LENDELL MINE

Response to Submissions 132 kV Powerline Relocation MOD 3 EA

for
Mt Owen Pty Limited
September 2016

RESPONSE TO SUBMISSIONS

Figure 4 conceptually illustrates the powerline relocation which is located entirely within the existing DA 80/952 Project Boundary (but external to the Disturbance Boundary). It also illustrates the proposed powerline easement (further discussed in **Section 8**).

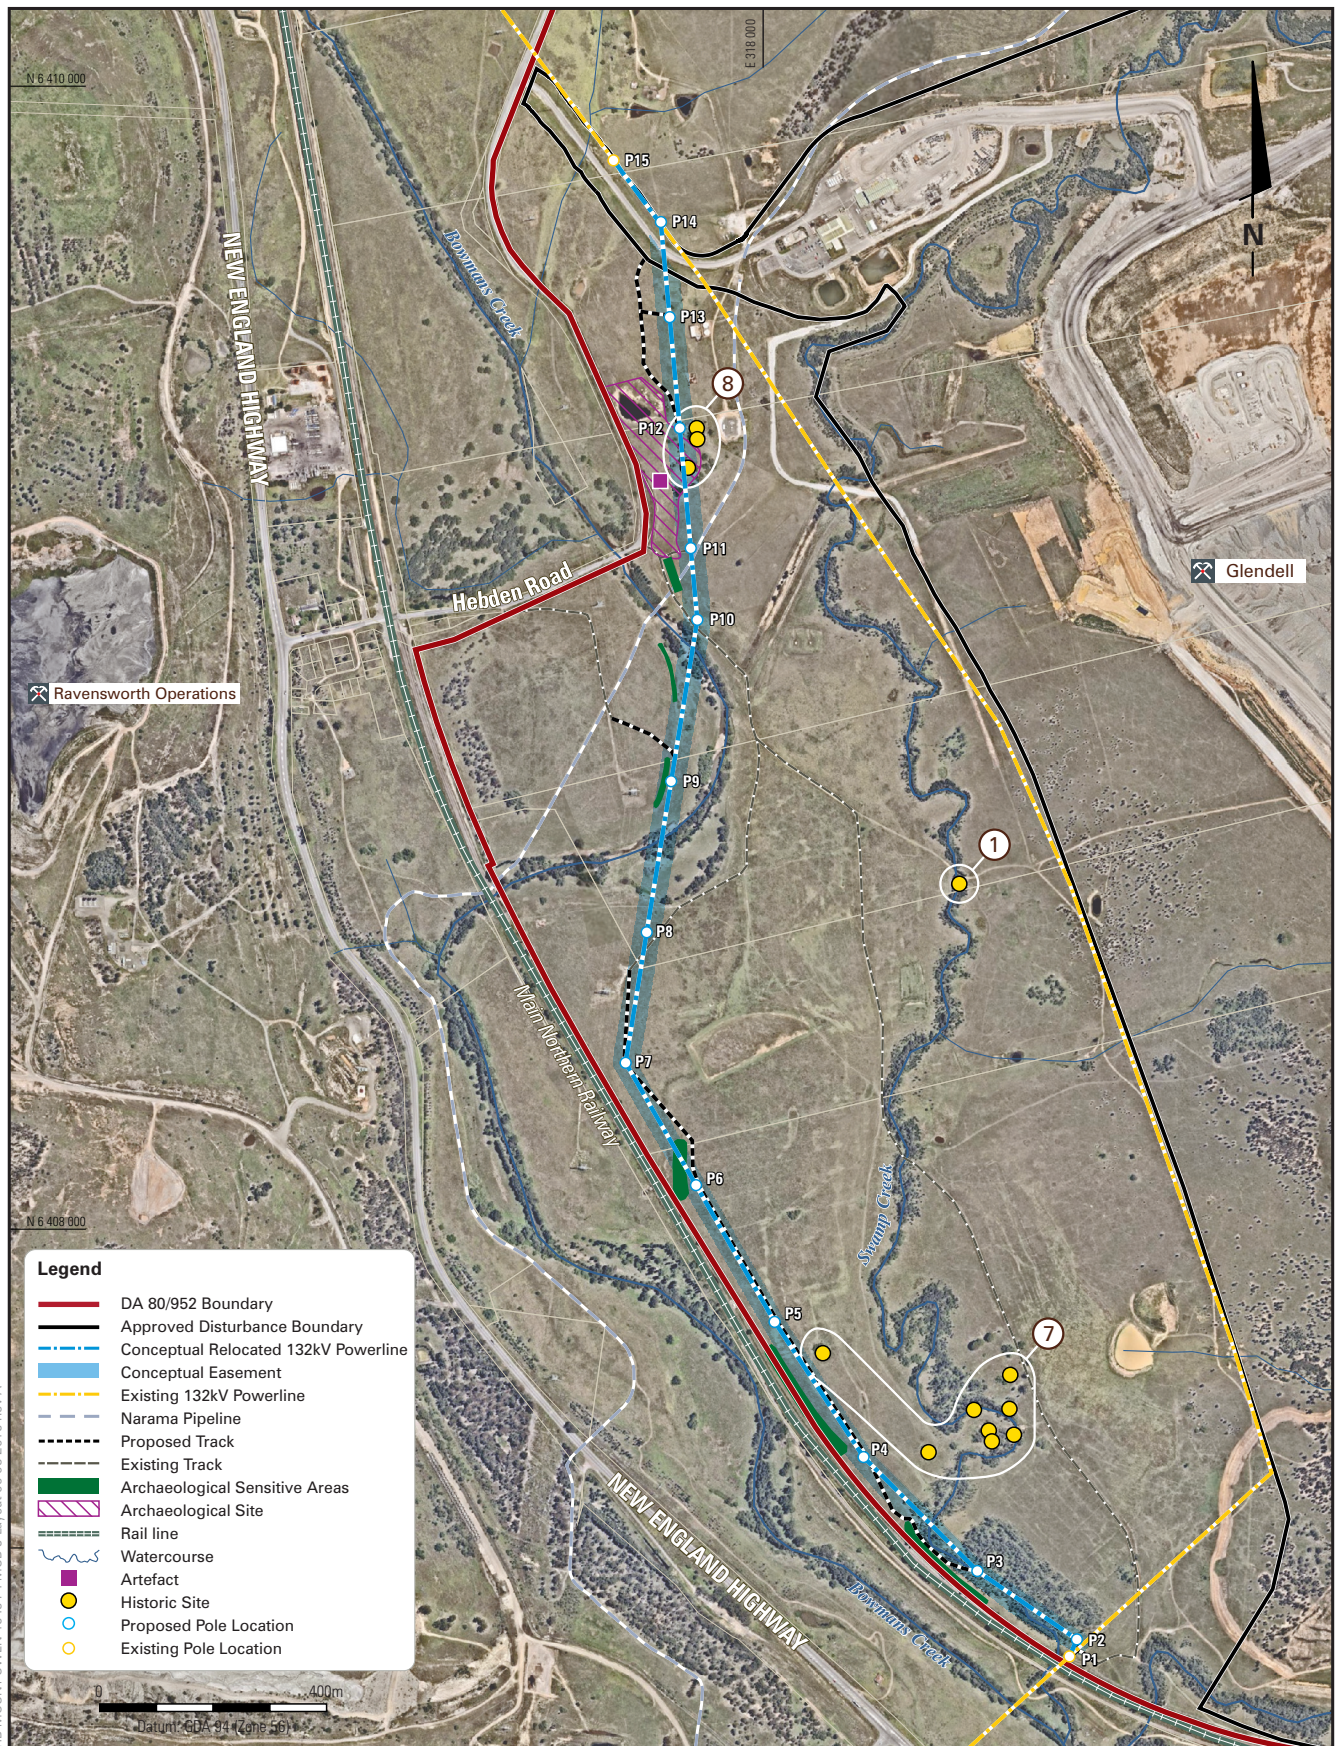
The modification includes the relocation of a powerline within the DA 80/952 project boundary but outside the disturbance boundary with Figure 4 depicting the conceptual powerline easement.

Refer to **Section 2.2.3** which addresses impacts to waterfront land and outlines additional specific management measures proposed to be implemented during the construction and operations of the powerline.

Figure 6-4: Proximity of the Study Area to MOCO OS-10 and recorded artefacts.

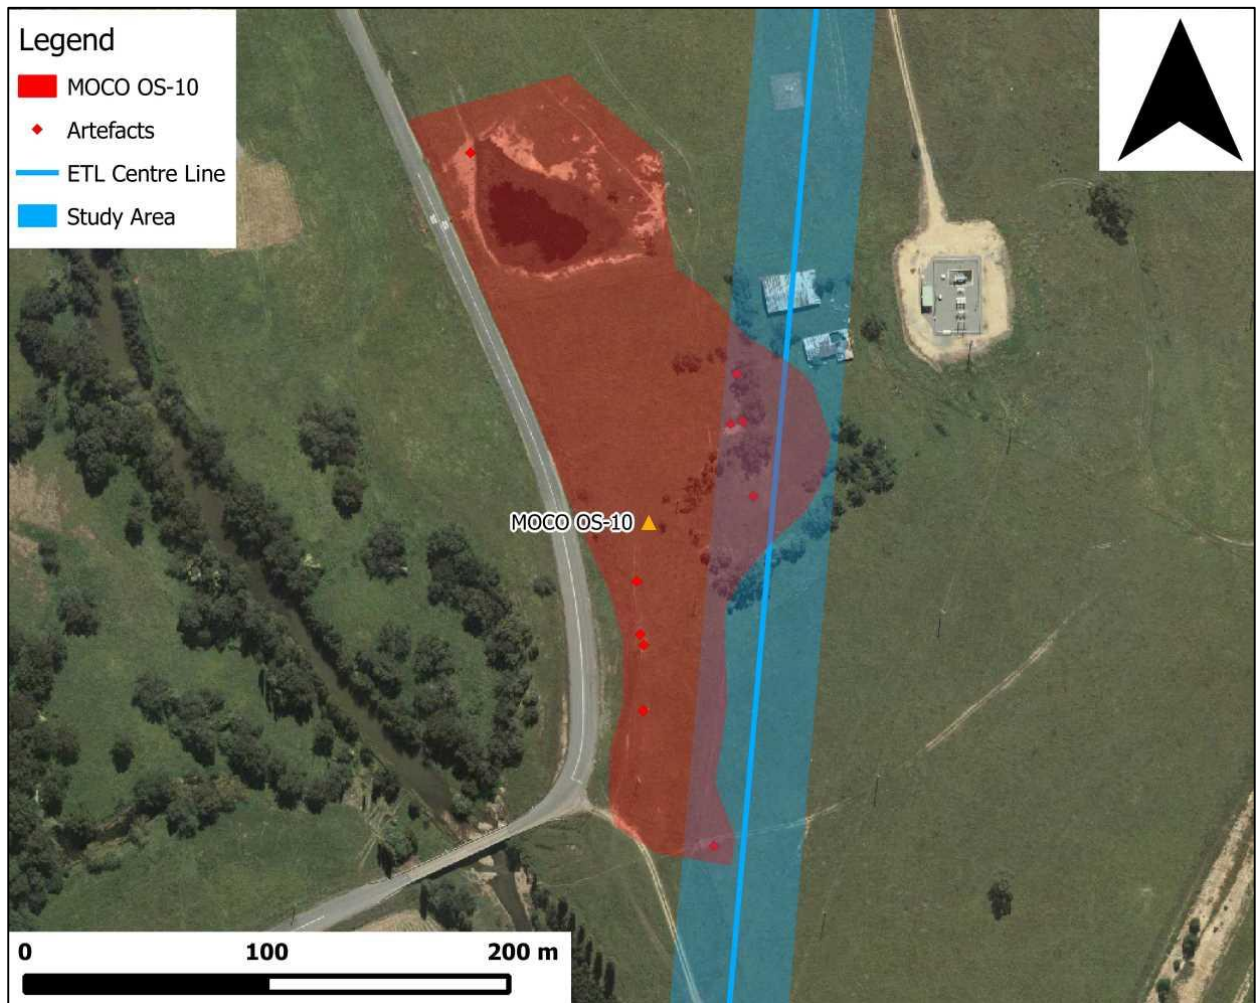
- Site MCO OS-10 is to be avoided by the activities associated with the powerline relocation. This includes not establishing any new access tracks within MCO OS-10. The existing track to the house/sheds can be used without any grading or widening;

- MCO OS-10 is to be bordered by temporary fencing with a five metre buffer and 'Do Not Enter' signs attached;
- Induction and training is to occur to ensure MC OS-10 is not accessed or disturbed by the construction workforce;

Noted.
